PRAIRIERIDGE FILING NO. 1

RR-2.5 Rezone Map

REZONE EXHIBIT REVISED

PRELIMINARY PLAN
 REZONE EXHIBIT
 ZONING RR-2.5

REZONE EXHIBIT

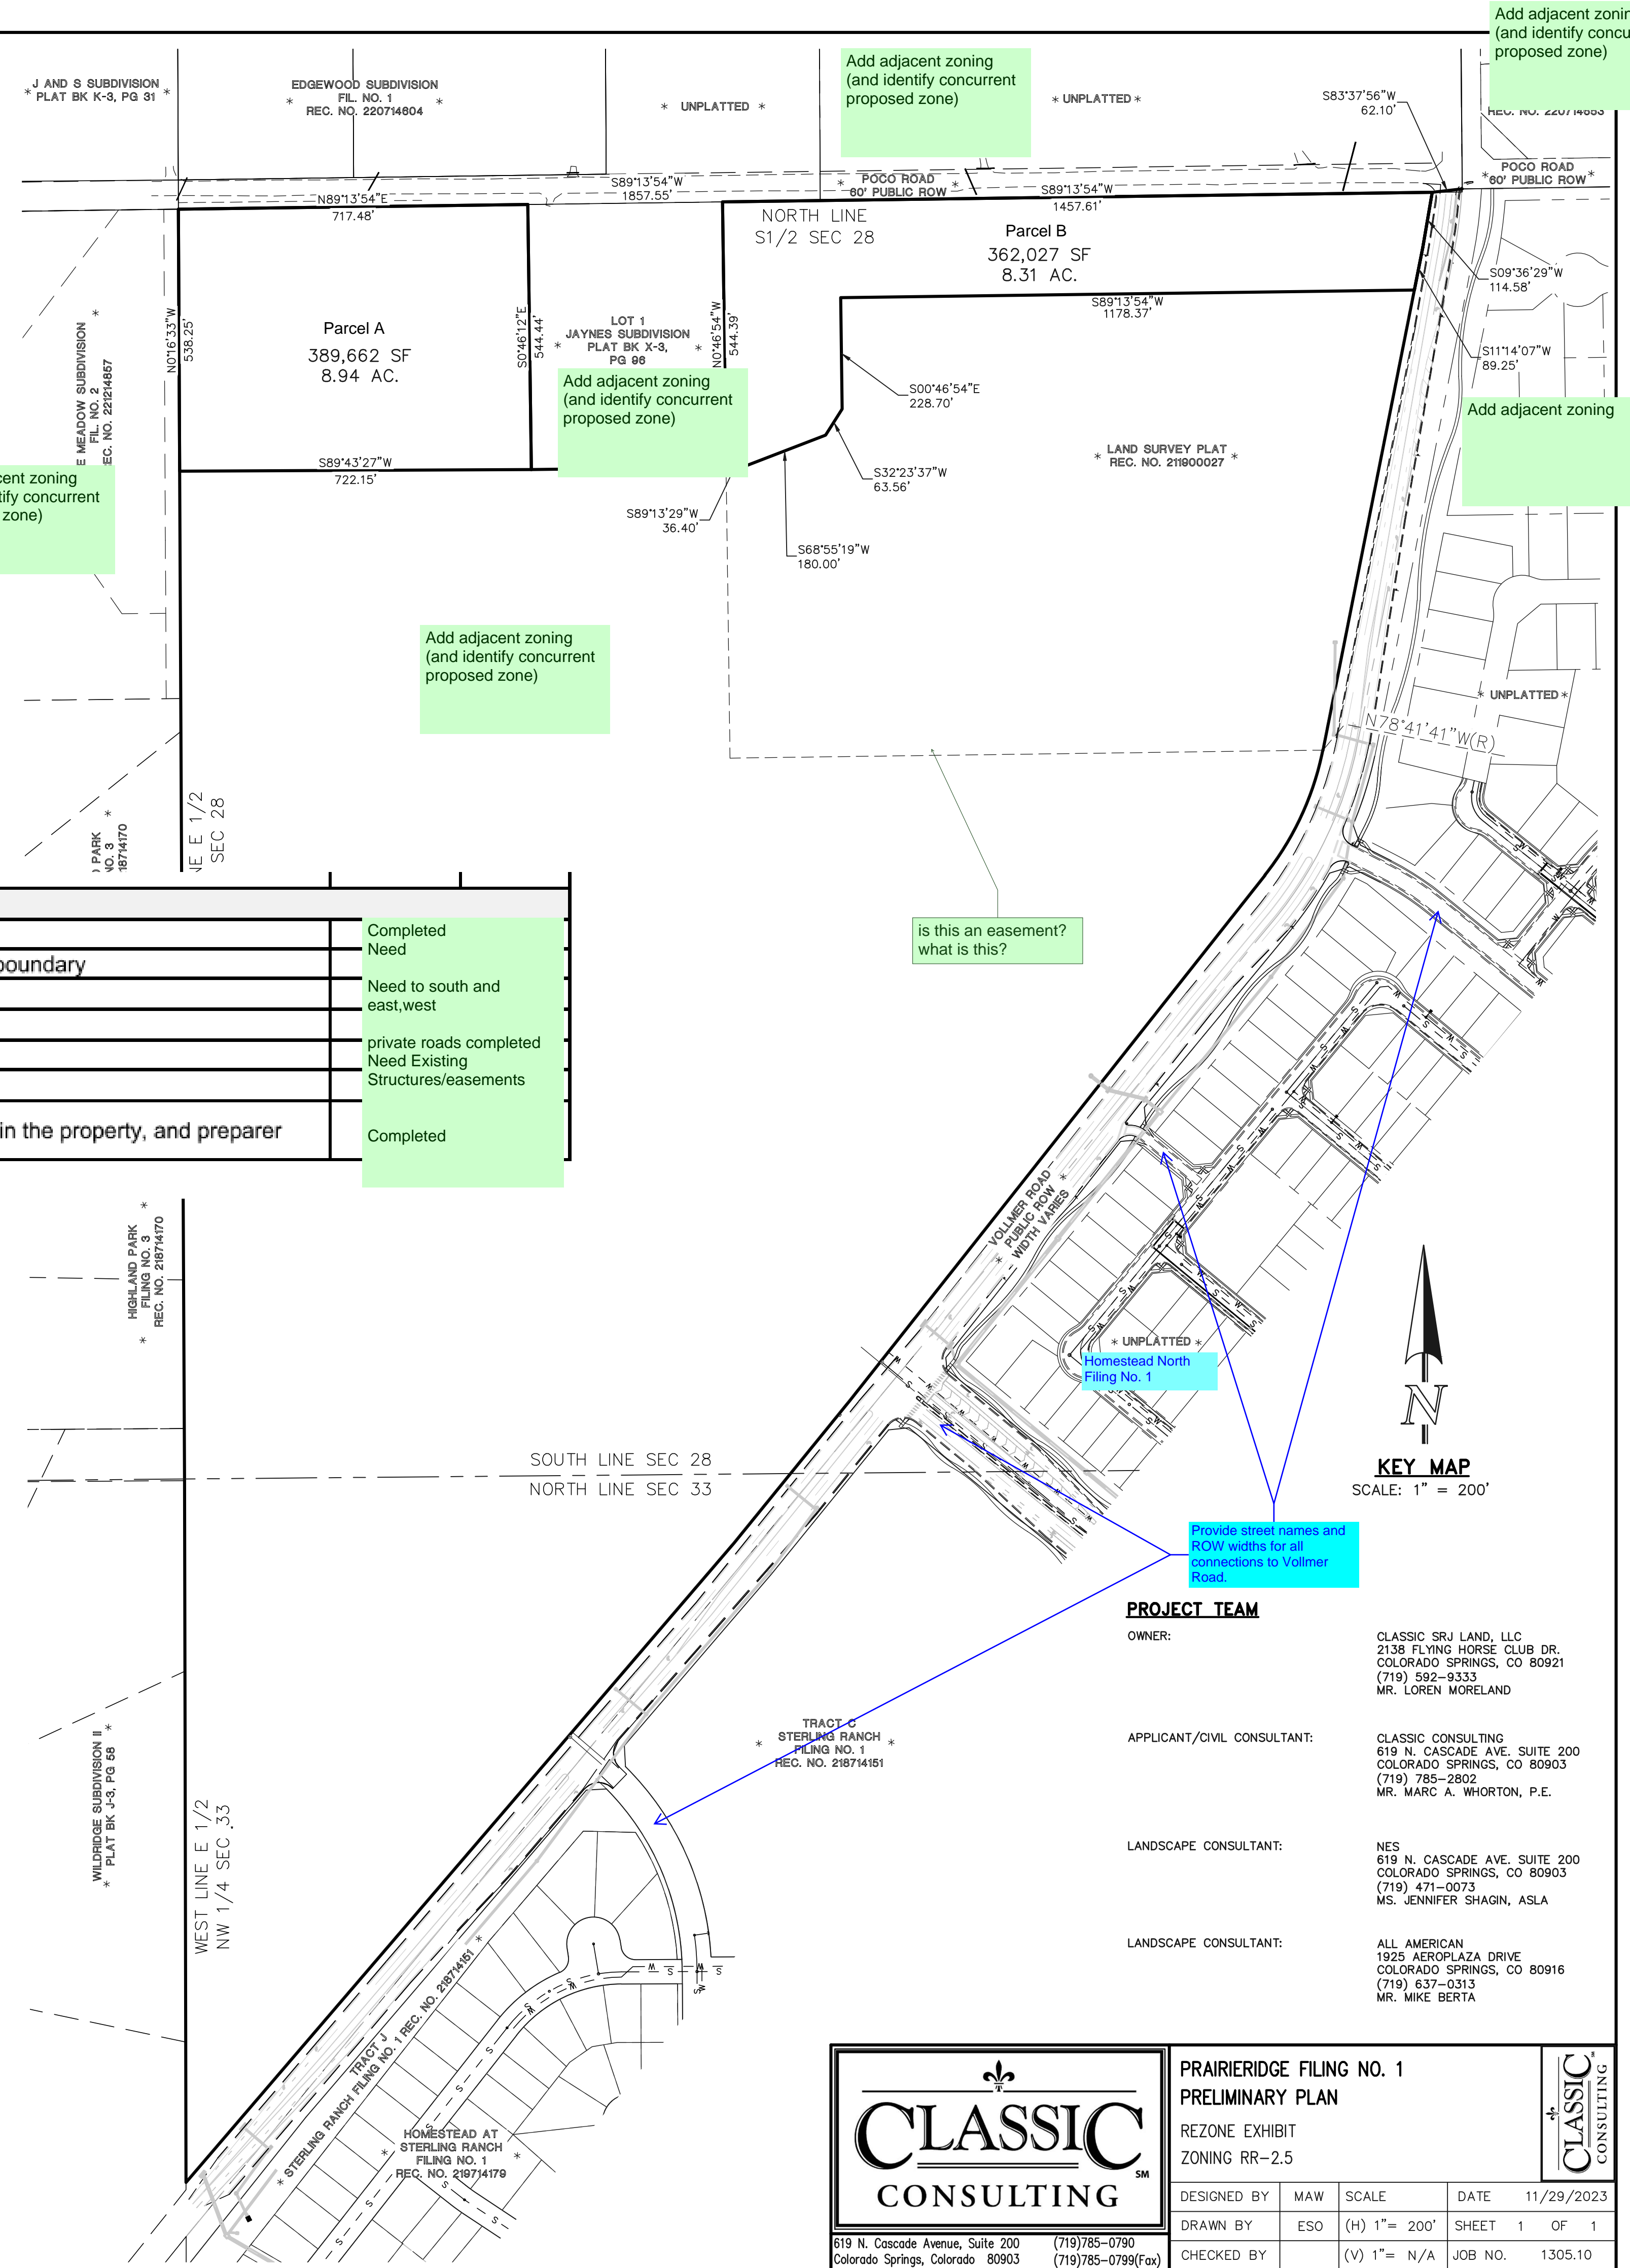
Provide street names and ROW widths for all connections to Vollmer Road.

Adjust for this rezone area

is this an easement? what is this?

Add adjacent zoning (and identify concurrent proposed zone)

NO PRIVATE ROADS
WITHIN THESE TWO
PARCELS

NO IT IS A
CURRENT
PARCEL LINE
